Date: 12th March 2013
To: Planning
Cc: -
From: Miriam Hill
Subject: S6/2013/0411/FP – Nolita Restaurant, Great North Road, Hatfield
Demolition of existing garden bar and refurbishment/reorganisation of the existing customer terrace; erection of single storey rear extension and electricity substation in car park; and alterations to

I have reviewed the proposal for the above site and refer to drawing number 3380/001 and 3380/203 rev A.

Brand			
B.U.N. No.			
Site	Nolita Potters Bar		
Title	Proposed Site Plan		
Project Manager/Drawn By	DH	Scale	Date
		1:20 & 1:100	Feb 13
Arch. Des. / Drawing Number	3380/203	Rev.	A

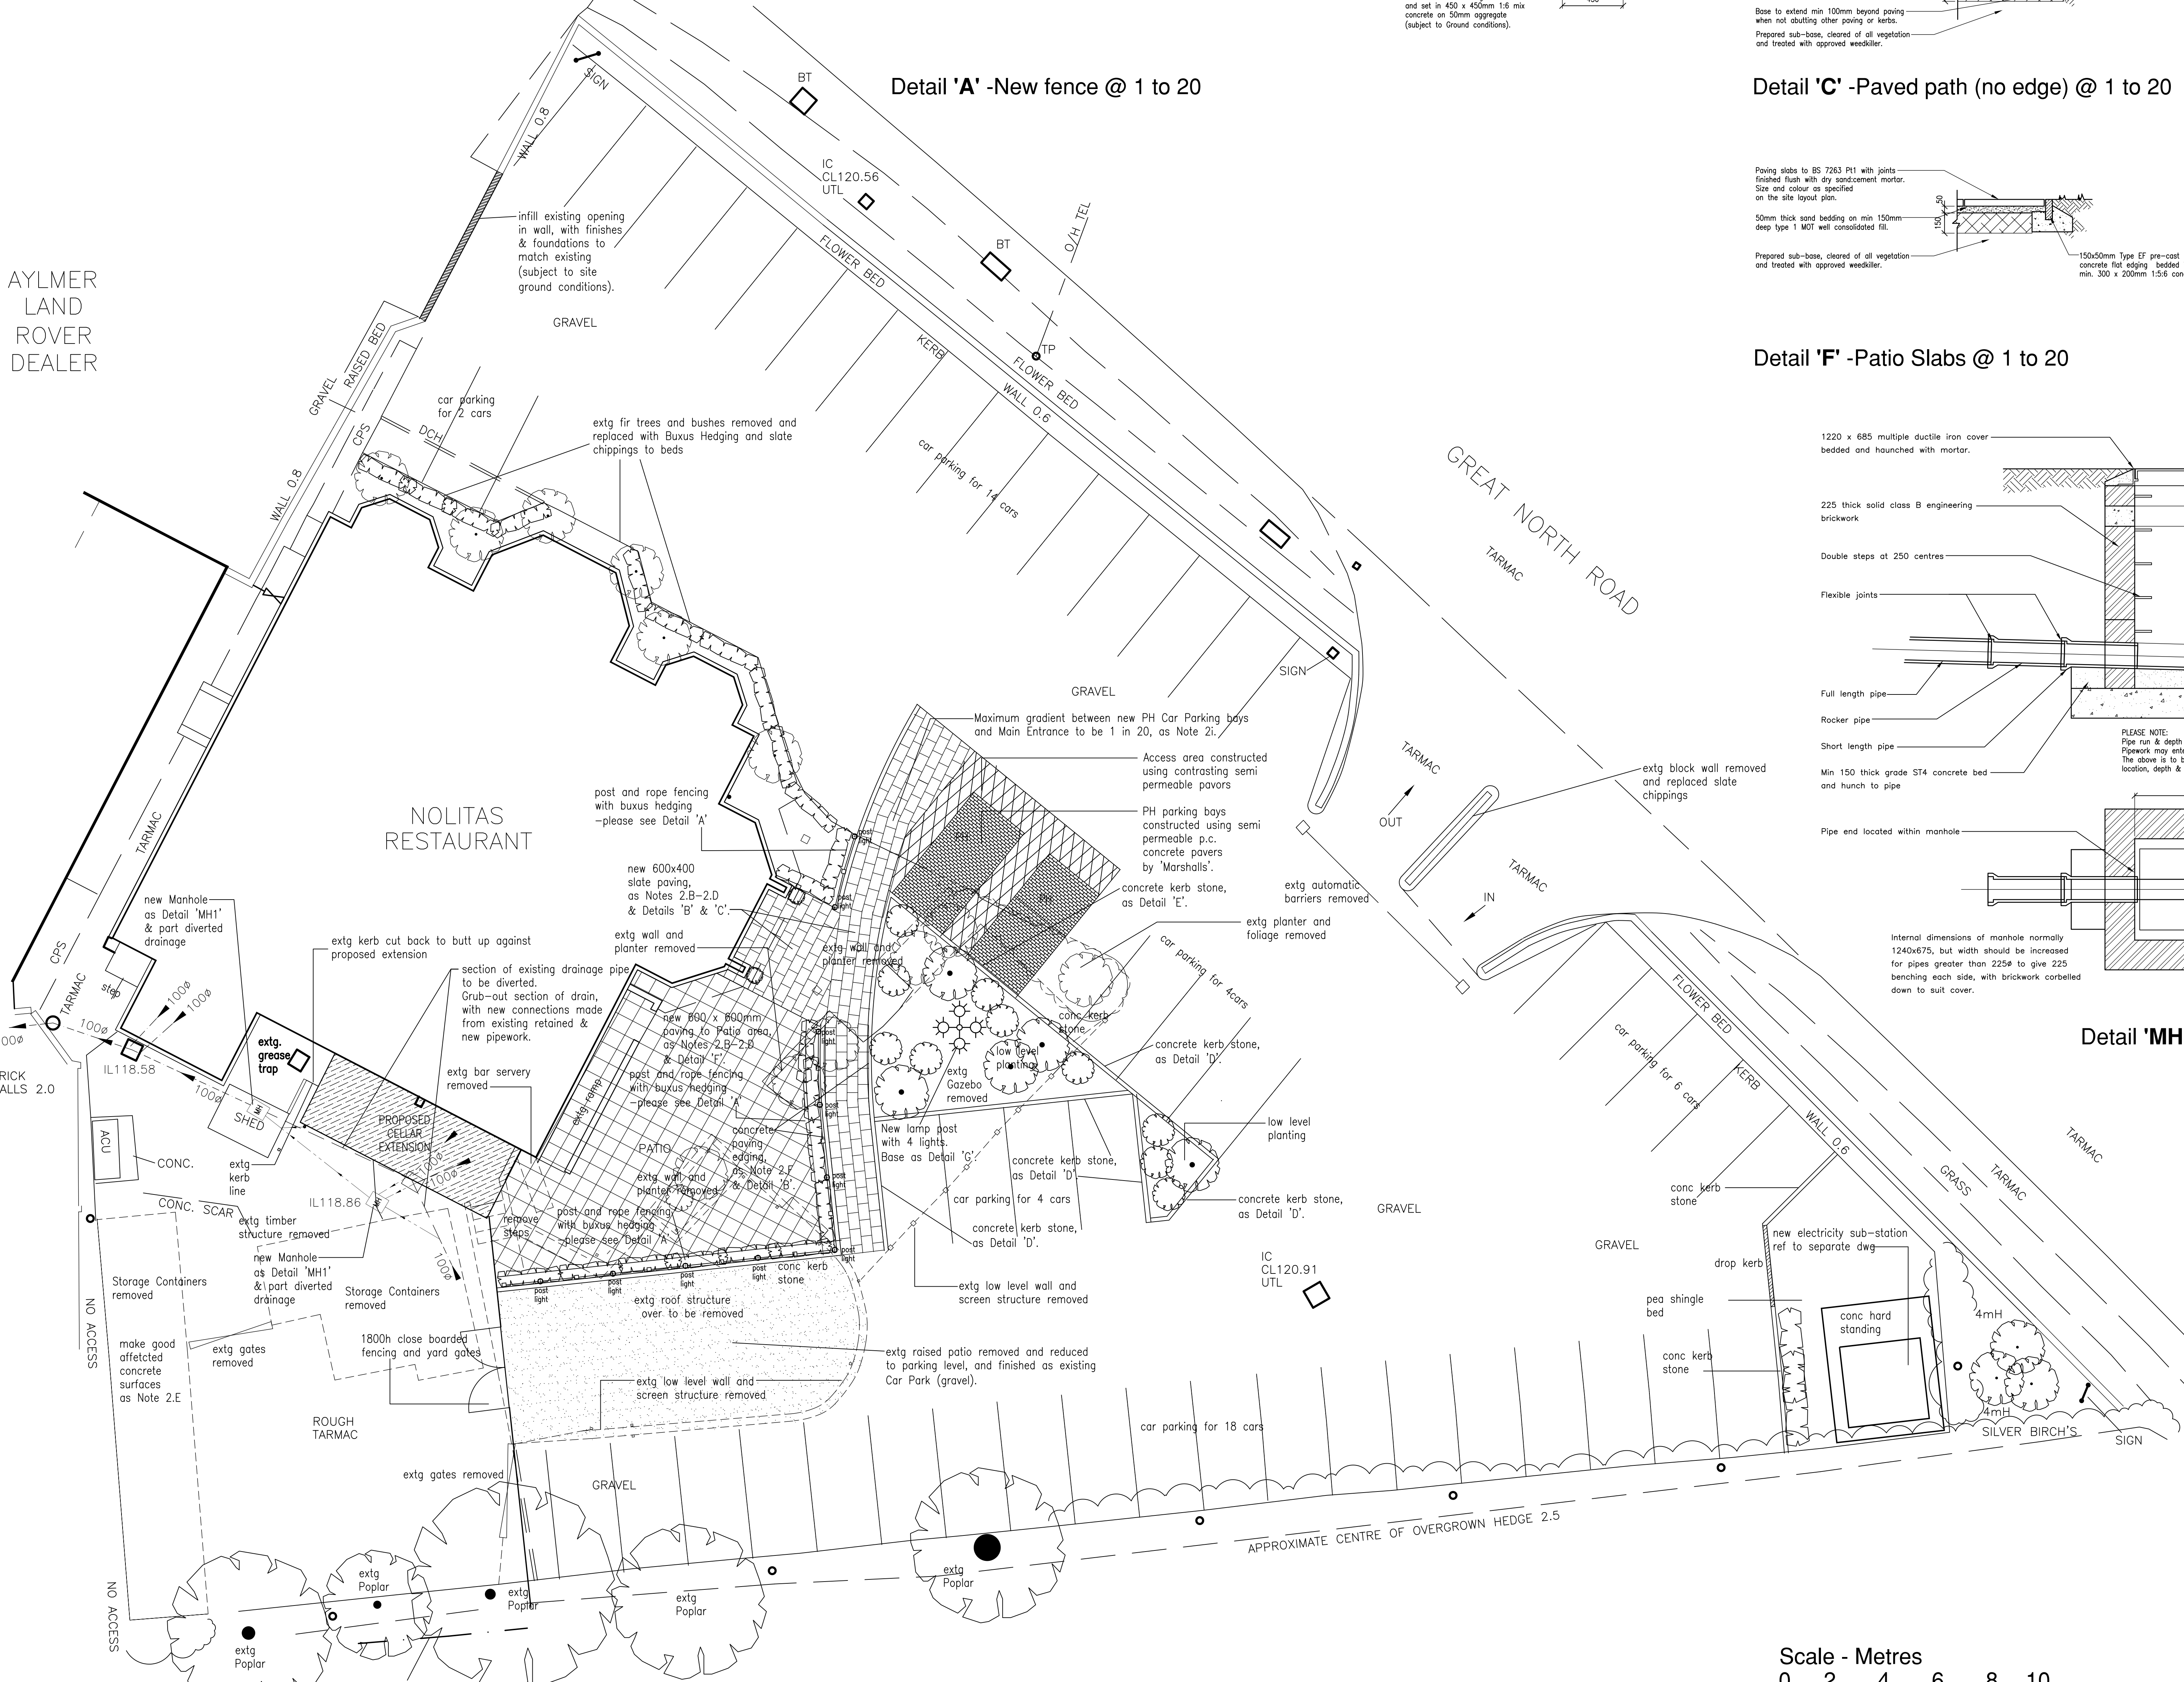
No detailed landscape information was included in the application. Plan 3380/203 rev a, external works notes suggests a landscape scheme has or will be undertaken by a specialist sub-contractor. A condition of approval can be the submission of this plan.
